Training, Logistics and Property
Telephone: (02) 9620 0765
Our Reference: 2015/5506
Your Reference: SSD6917

Re: SSD6917 Oakdale South Industrial Estate, Erskine Park, Penrith LGA - Notice of Exhibition

- Sydney South to Sydney West No.1 330kV (Feeder 30 Structures 10–13) (**Easement**)

SSD6917 - Oakdale South Industrial Estate, TL: Syd Sth - Syd West No.1 330kV (Fdr 30 Str 10-13 & Fdr 14 Str 110-111)	
Property of Transgrid. No warranty is given that information shown is complete or accurate.		PRODUCED FROM TAMIS	Scale: 1:15000
18/11/2015 15:14:49 Created by: P86665		A4

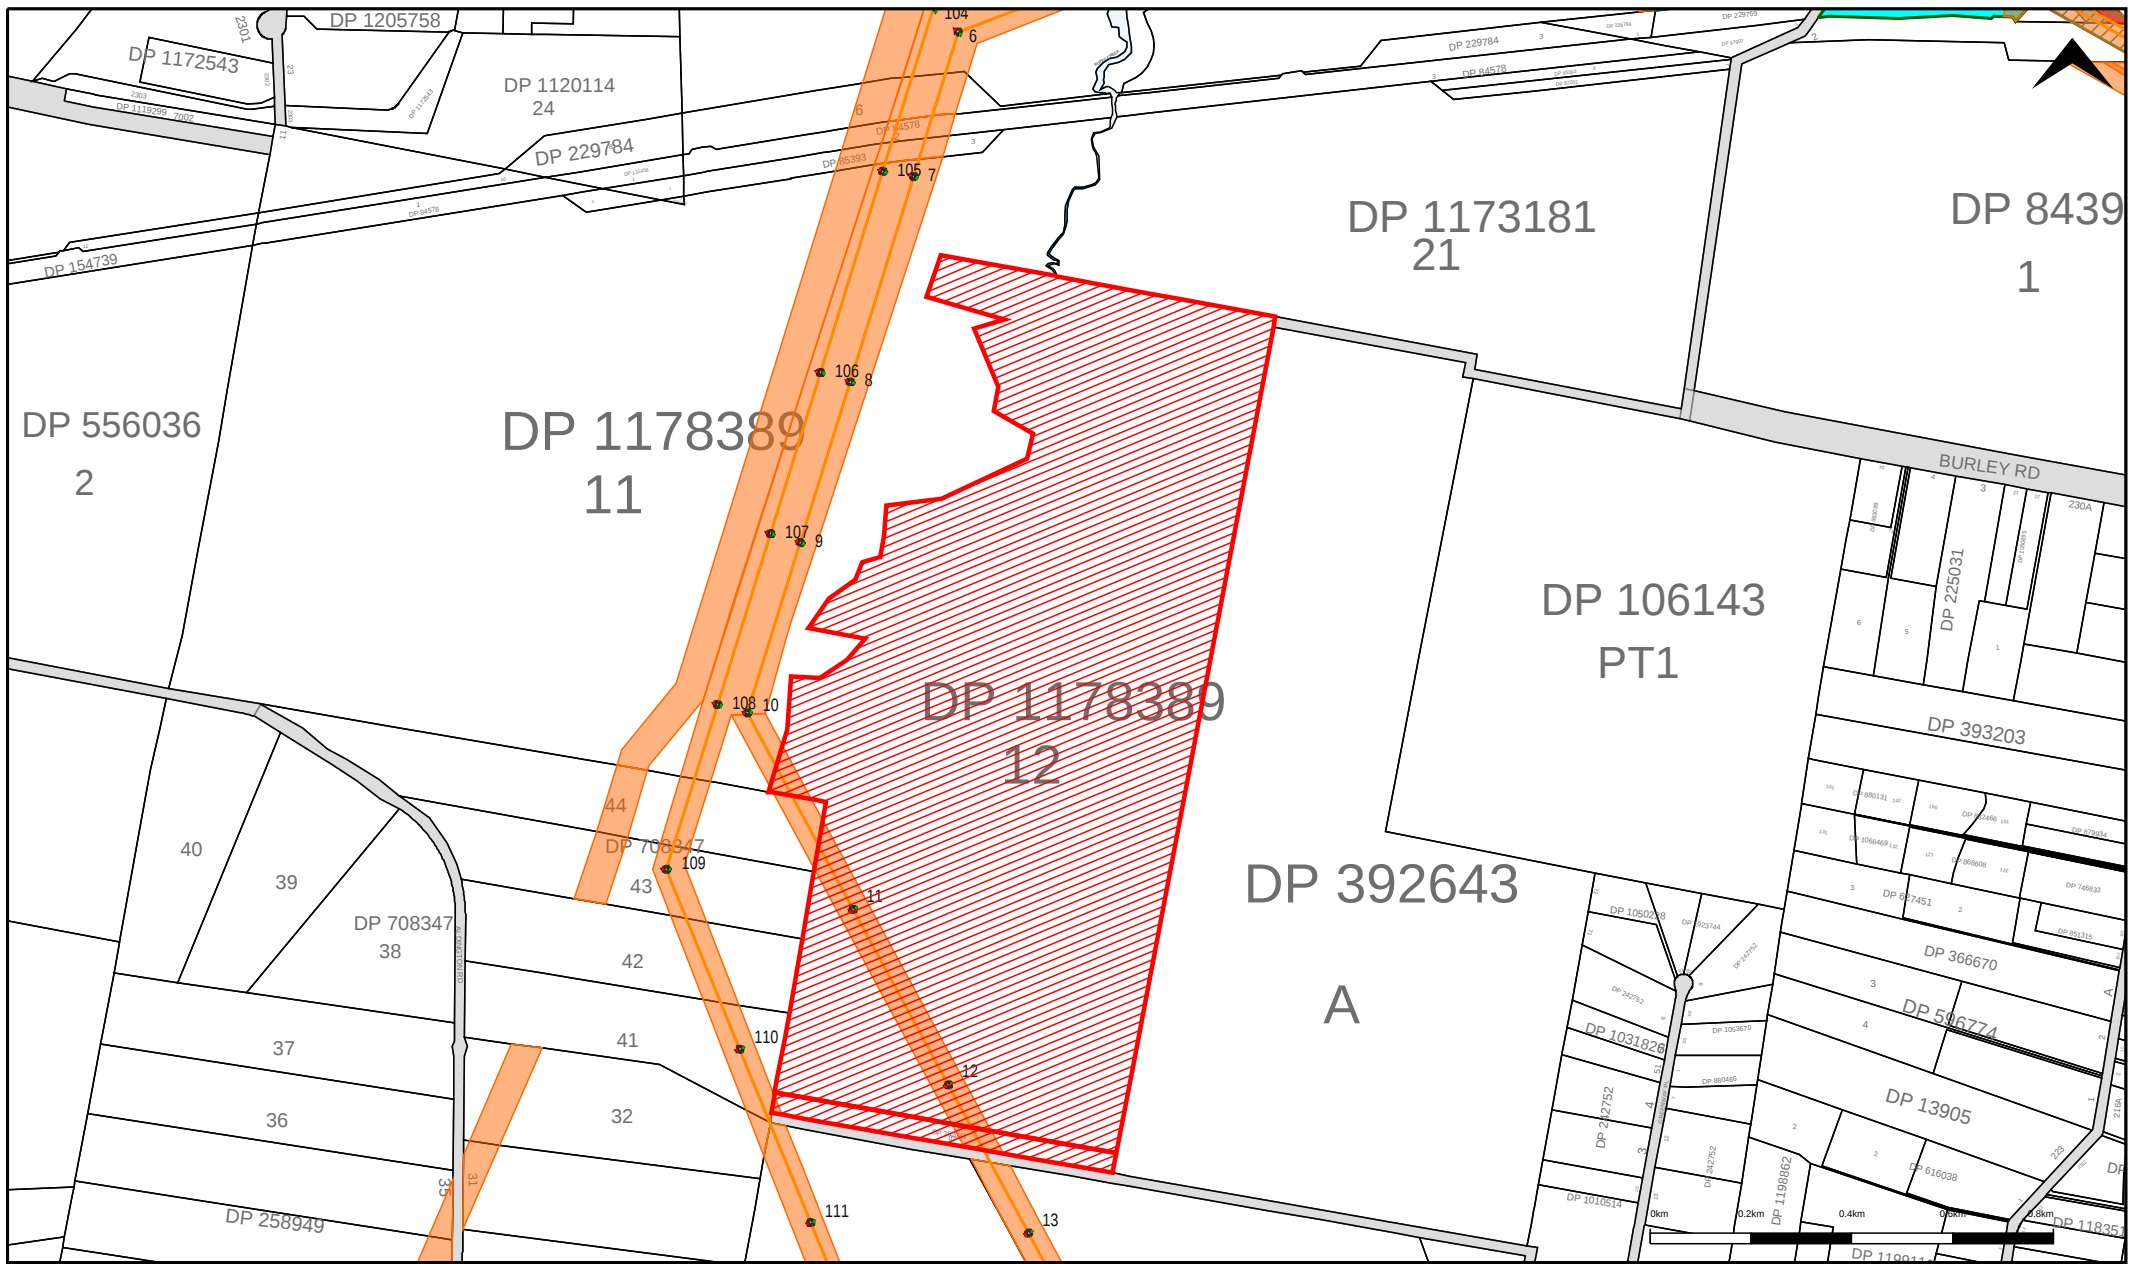
This easement traverses the subject land pertaining to the *Oakdale South Industrial Estate* within a 60.96 metre wide easement. A formal survey plans identifying the exact position of TransGrid's easement and the infrastructure therein will need to be arranged by the developer to ensure that the exact position of the easement is accurately accounted for and that no prohibitive encroachment arises within the easement or immediately adjacent thereto.

Attached is a plan from the *TransGrid Asset Management Information System* (TAMIS) that identifies the approximate position of our easements and infrastructure on or near the subject land, along with a Deposited Plan (DP1153614) in respect of same.
